Reference Number: 2382/APP/2023/2906

DESCRIPTION: Redevelopment of the site to create the Hillingdon Watersports Facility and Activity Centre including demolition of existing Broadwater Lake Sailing Club (BSC) clubhouse at the north of the lake and erection of a building and facilities to be occupied by HOAC and BSC

LOCATION: Broadwater Lake, Moorhall Road, Harefield

Figure 5.4: Extent of Dredging Zones, Island Loss & Creation and Land Reclamation

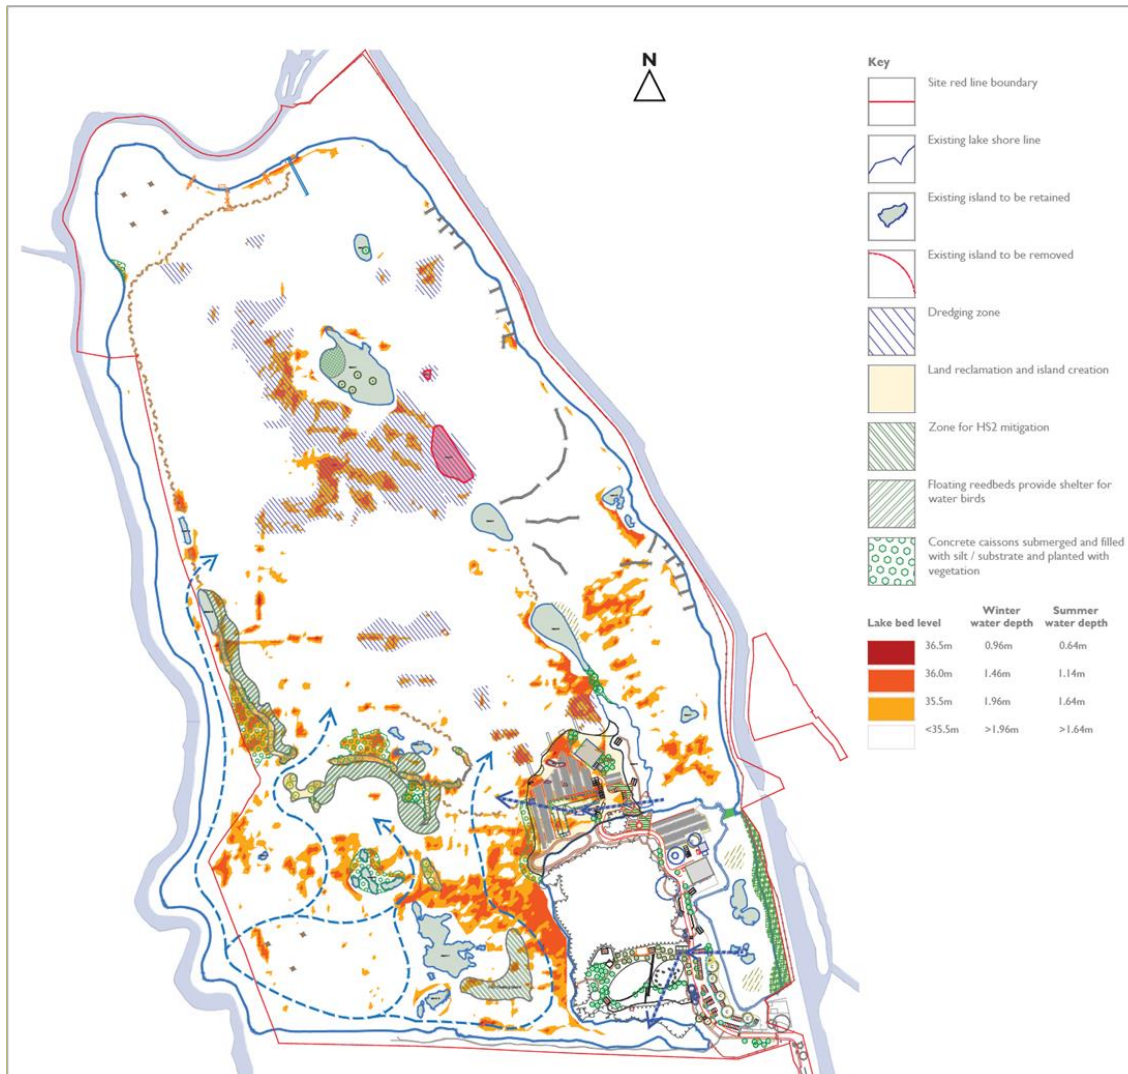
The proposed dredging activity has the potential to change the current connectivity between the lake and Chalk groundwater, along with the additional turbidity risk both to Chalk groundwater and the lake.

- A **Dredging Method Statement** that includes an understanding of the maximum depth of the dredging and the areas within the lake for which dredging will be undertaken.

Reason: To ensure that dredging is not unnecessarily over deepening or enhancing connectivity between the lake/superficial deposits and underlying Chalk aquifer.
